TfNSW reference: STH24/00075/006
Your reference: SSD-69257218 – PAE-80700714

SSD-69257218 – Mixed use development with in-fill affordable housing – Response to Submissions – LOT:1 DP:520502, LOT: 129 DP:3060 & LOT: 110 DP:131219– 25 Moss Vale Road, BOMADERRY

TfNSW has reviewed the information submitted as part of the Response to Submissions has provided Context in Attachment 1 and the following comments:

TREE CANOPY PLAN

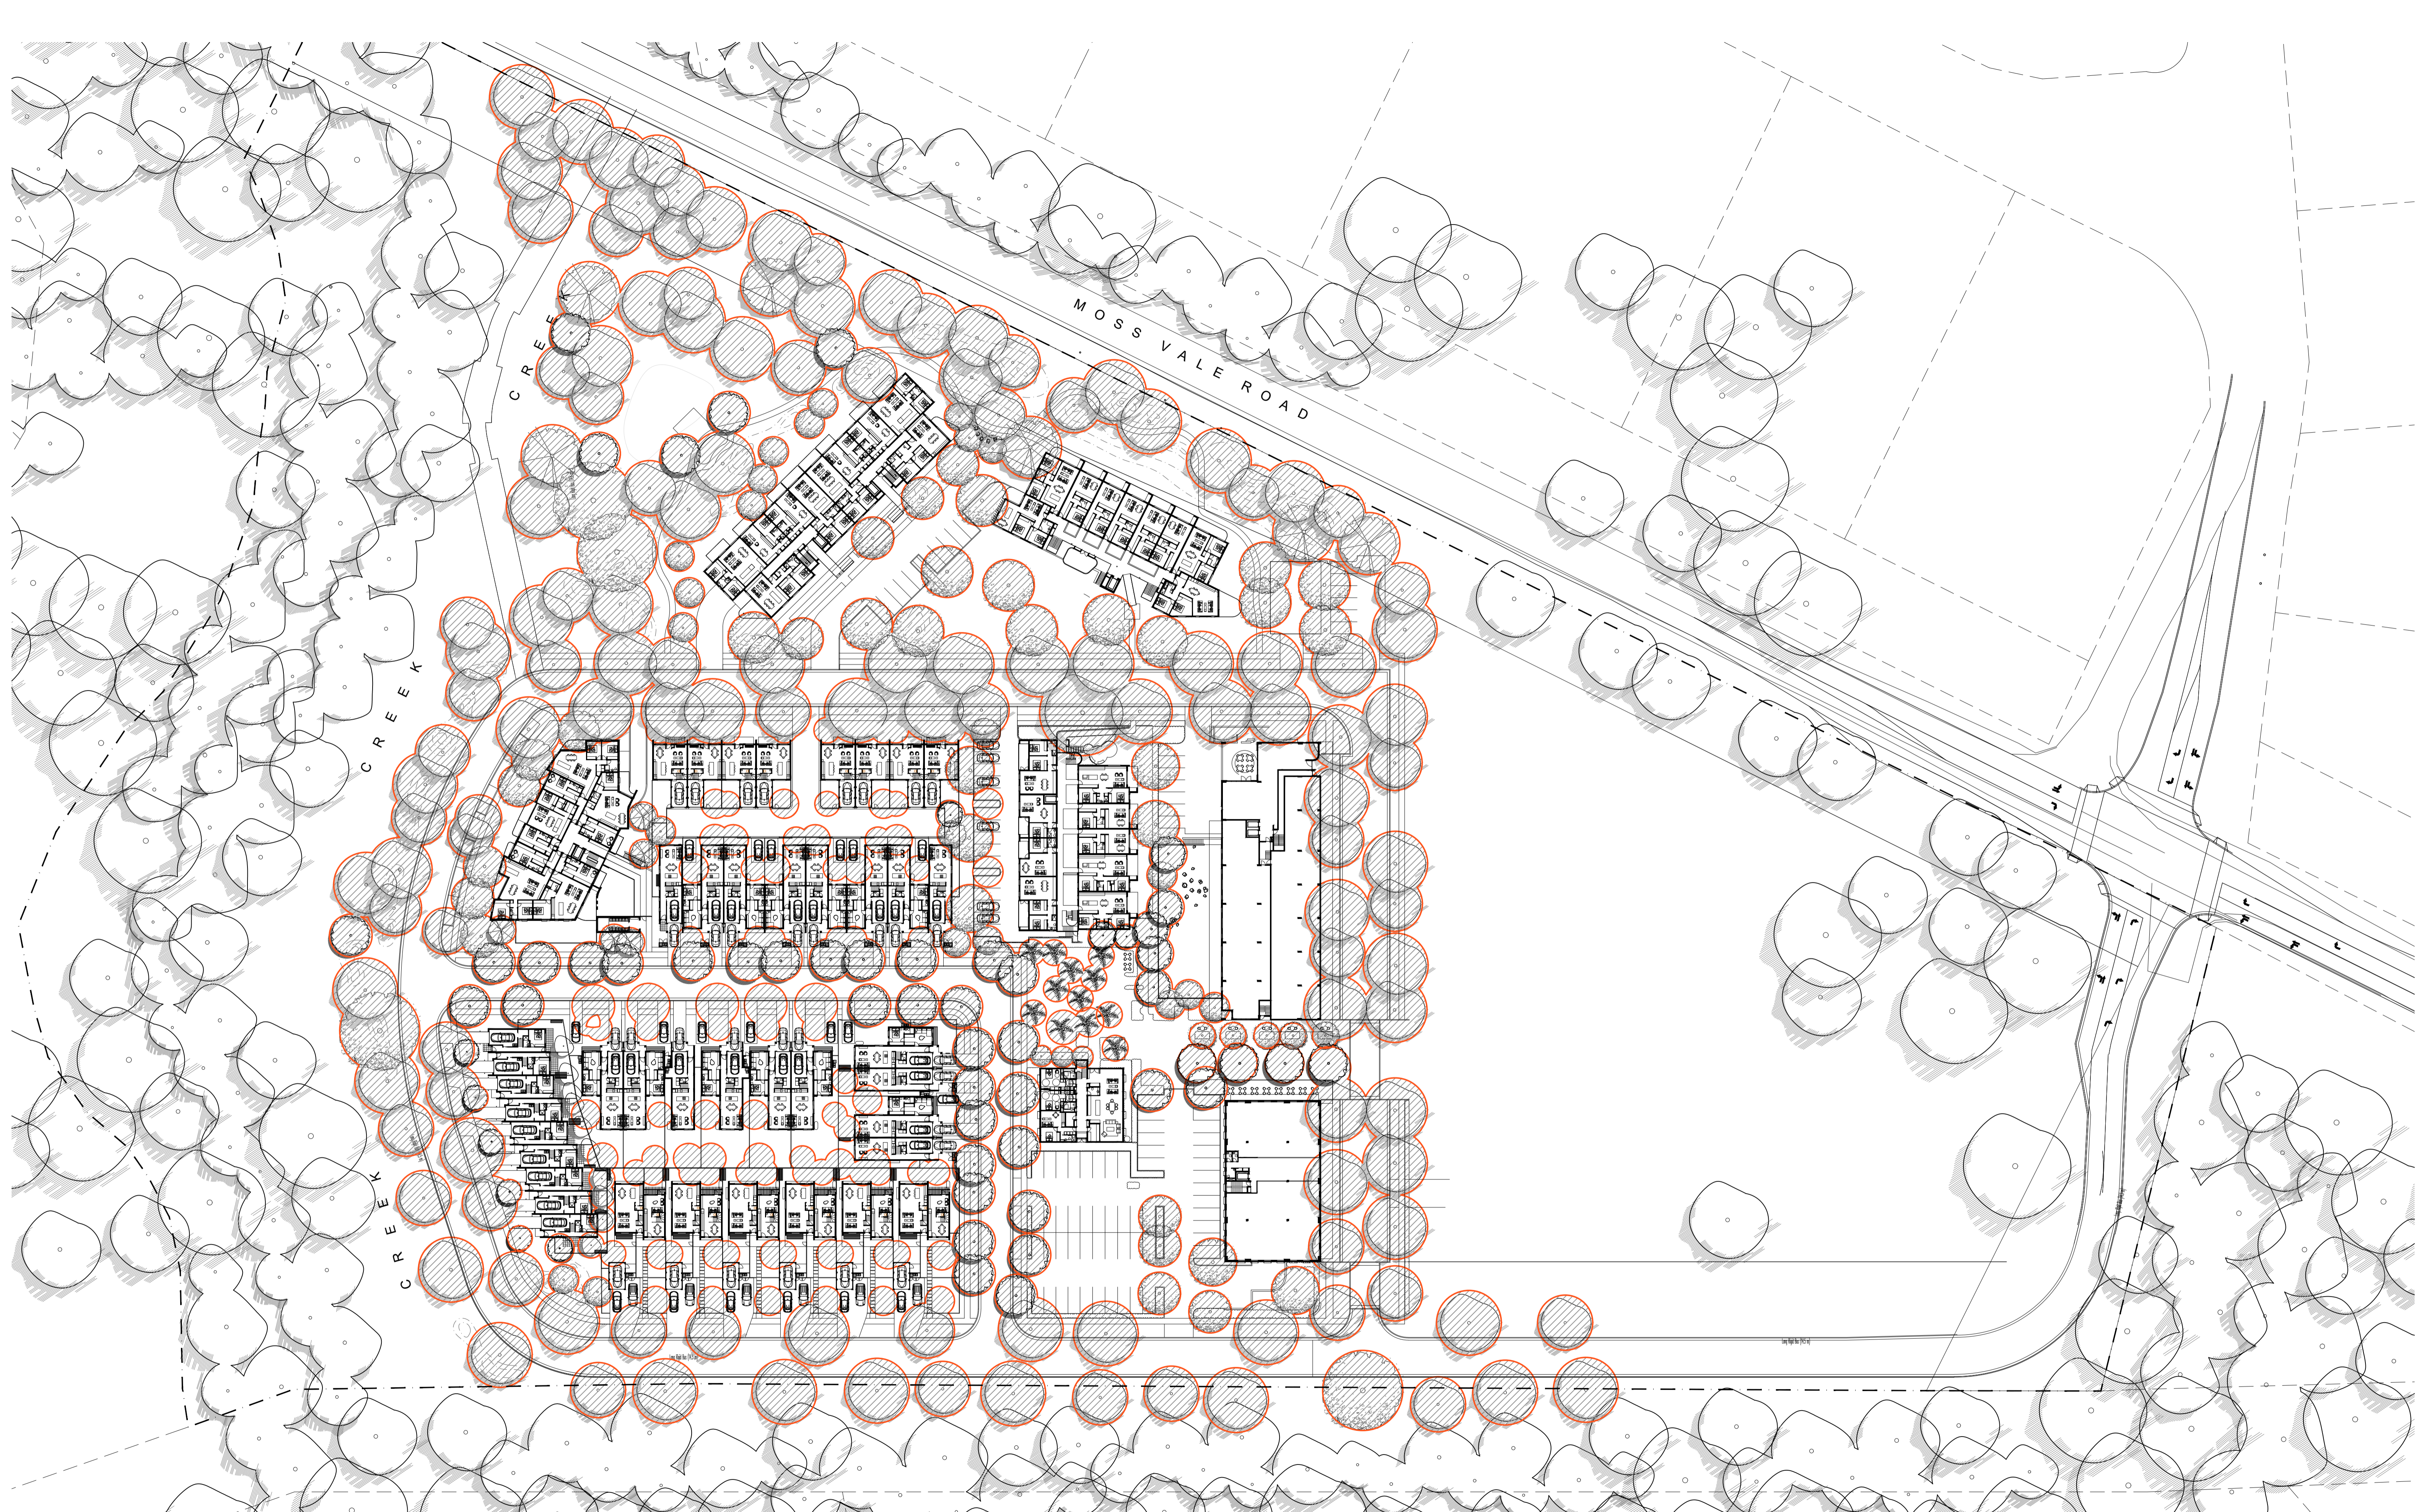
2. TfNSW notes that the Landscape plan indicates a shared path along the frontage of the subdivision and within the property boundary, as shown in **Attachment 3**. TfNSW also notes that the Shoalhaven City Council Active Transport Strategy shows a shared path at the frontage of the subdivision on the south side of Moss Vale Road. TfNSW believes pedestrian connectivity to the state road should be shown as this connection will enable future footpath connectivity to the state road boundary.
